DEVELOPMENT REVIEW BOARD  
SUPPLEMENTAL SUBMITTAL

PROJECT NO. 2018-001579

This letter outlines the modifications that have been made to the Apartments at Pennsylvania and Indian School application for a major site plan amendment to the approved Winrock Town Center Site Development Plan (PR-2018-001579) to address the agency comments that were received.

APARTMENTS AT INDIAN SCHOOL & PENNSYLVANIA  
 7500 INDIAN SCHOOL RD NE  
 ALBUQUERQUE, NM, 87110

SHEET NO. **SDP1.1**  
OF

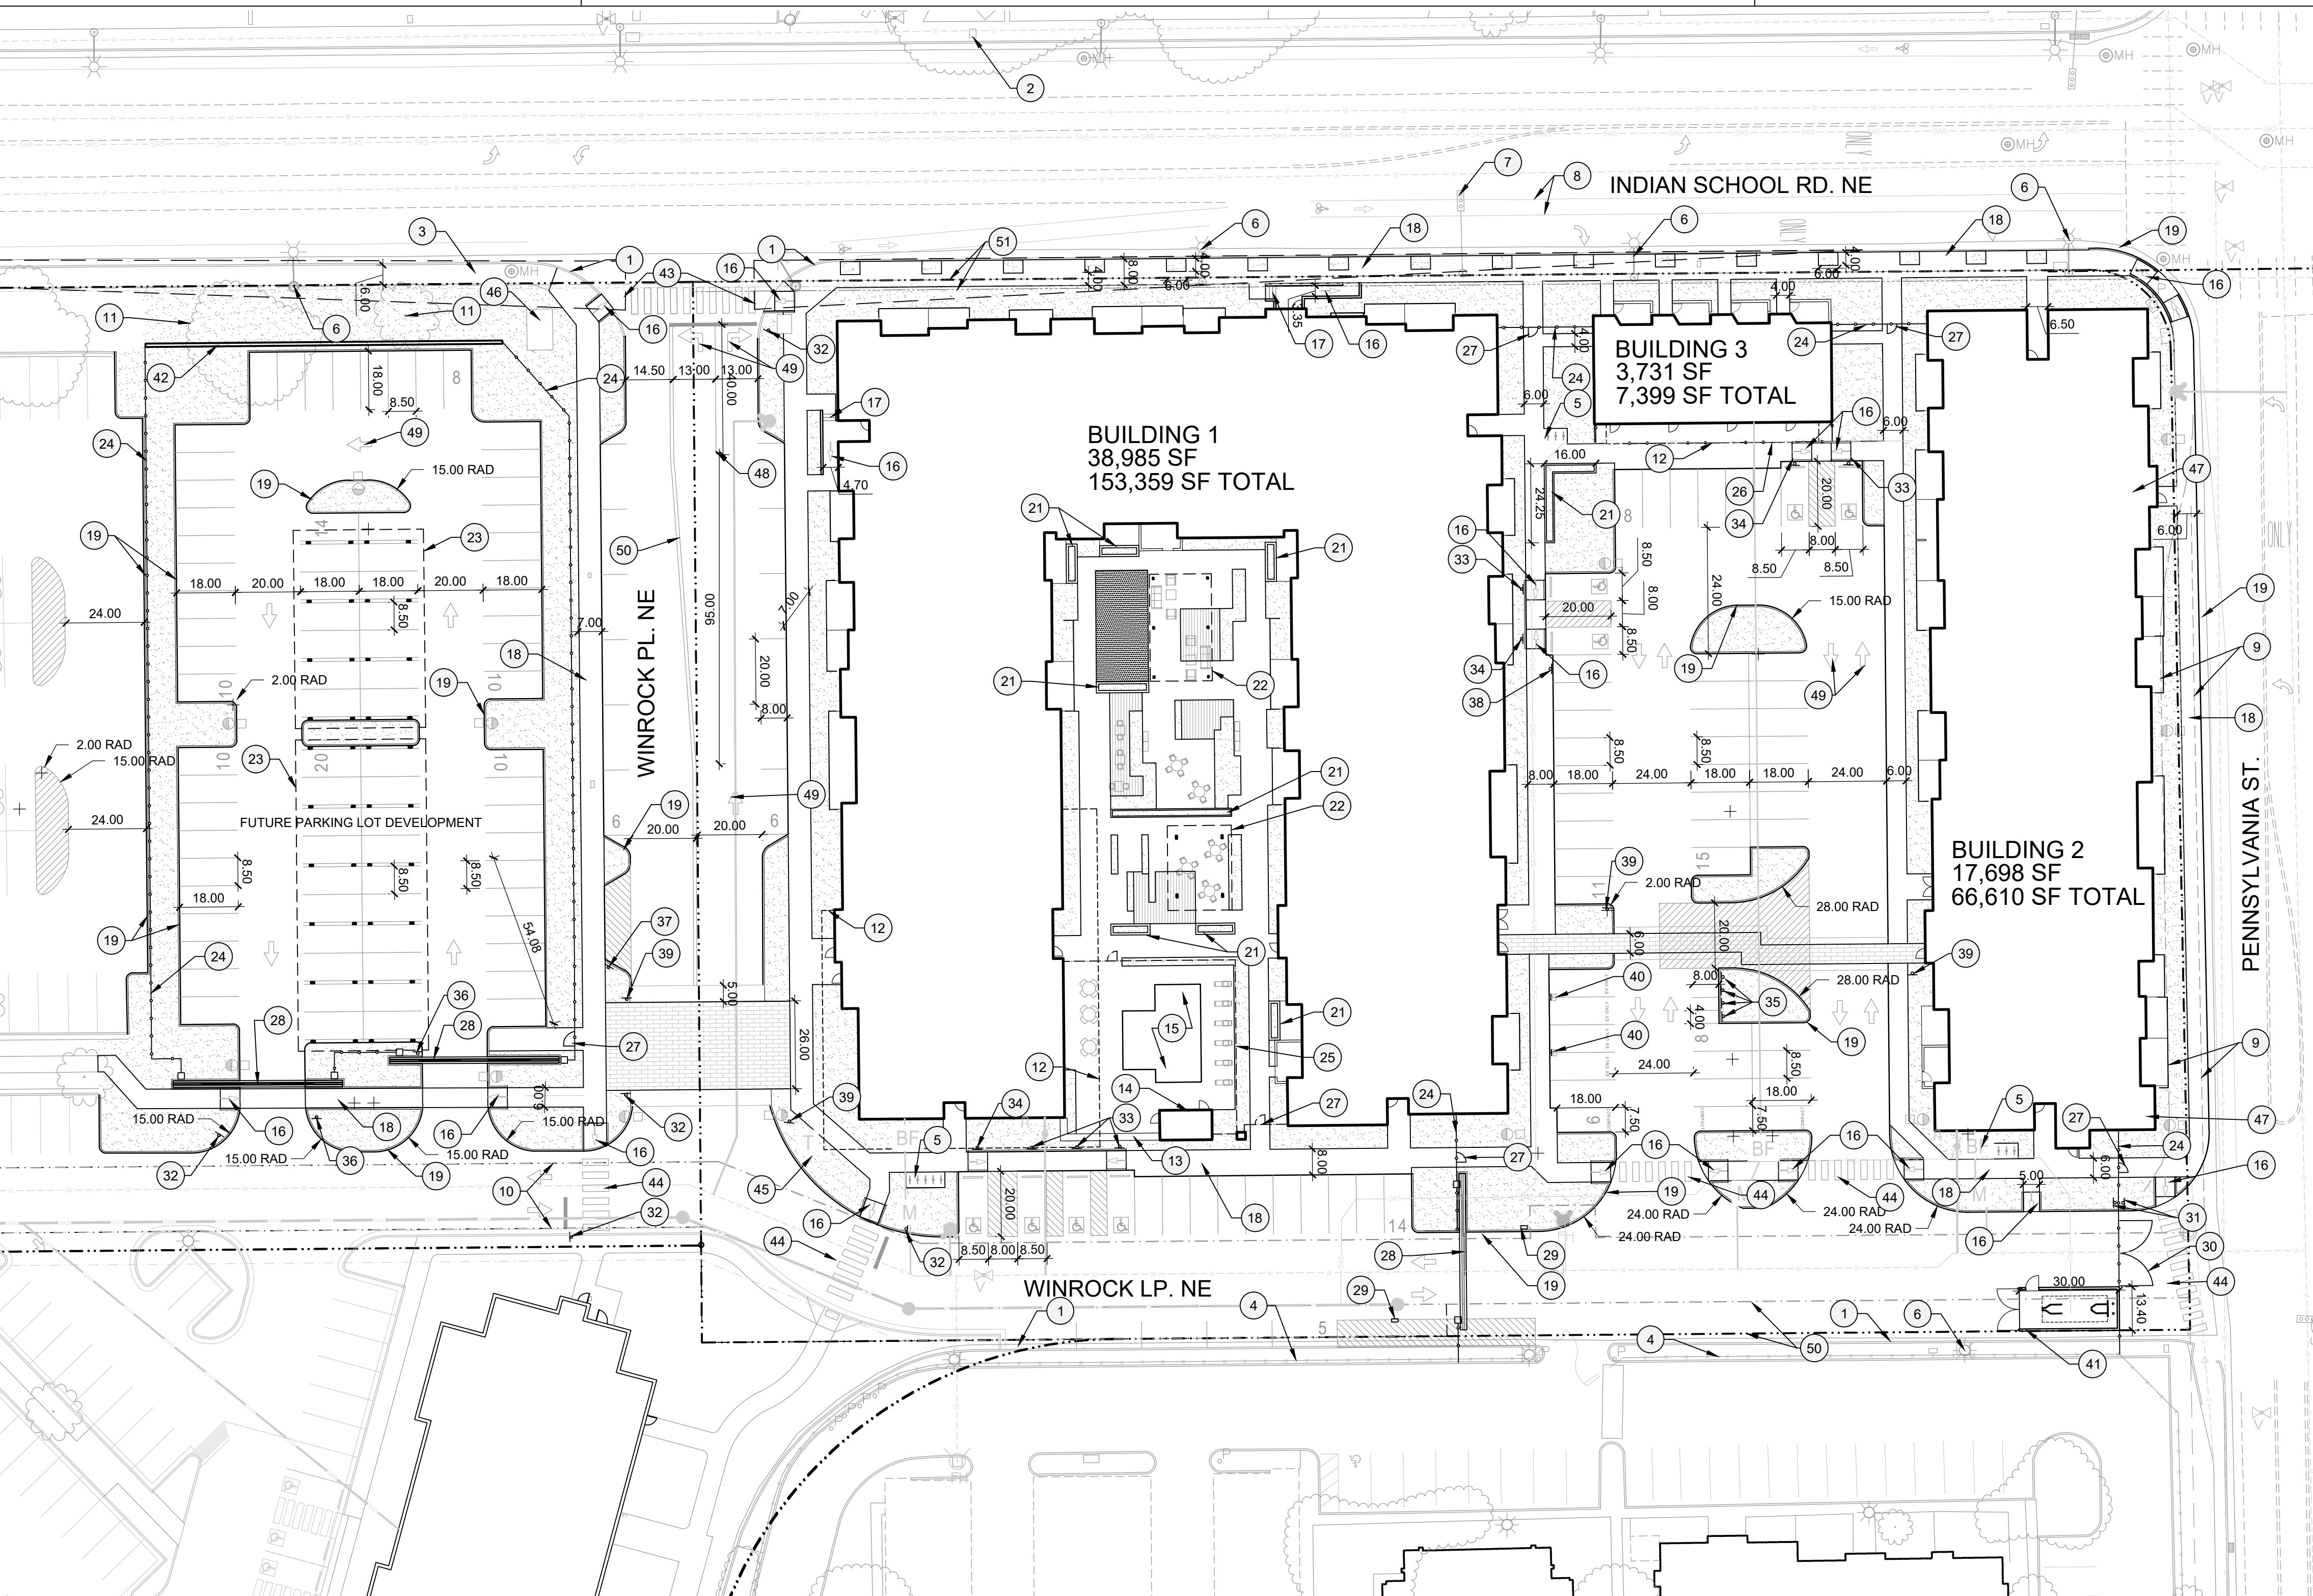
- 8. Clear sight triangles based on speed limits per the new DPM shall be shown; adjust landscaping as needed. Show matching clear sight triangles on site plan and landscaping plan.**

- 9. Include "Emergency Access Only" signage on each side of the drive off of Pennsylvania. Include Knox box and Fire Marshall approval.**

- 10. Curb should separate parking spaces from driving aisles in all cases. (A parking space on the east parking lot is unprotected.)**

- 11. Where are the electrical charging stations and the bike rack? Meet standard dimensions for bike rack per the IDO.**

*The applicant has added clear site triangles per DPM at the intersection of Winrock Loop and Indian School per meeting discussion with Jeanne Wolfenbarger on Tuesday, January 26<sup>th</sup>, 2021. Landscape plan has been adjusted accordingly. Adjustments made to direct access from the site onto Indian School Rd, due to the assignment of "emergency exit only" onto Pennsylvania St, modified clear sight triangles were not applied as this is not considered an intersection.*

*The applicant has added “emergency access only” signage on each side of closed off driveway. Signage detail is added to the SDP1.2 sheet. An approved Fire One plan has been obtained for the site. Knox box shall be included per the fire marshal’s requirements.*

*The applicant has reviewed all parking spaces and has verified that all parking spaces are protected.*

*Electric Vehicle (EV) charging stations are located at the southwest corner of the east parking lot and marked by keyed note 40. Bike racks are shown on the legend and detailed on SDP1.2 per IDO requirements.*
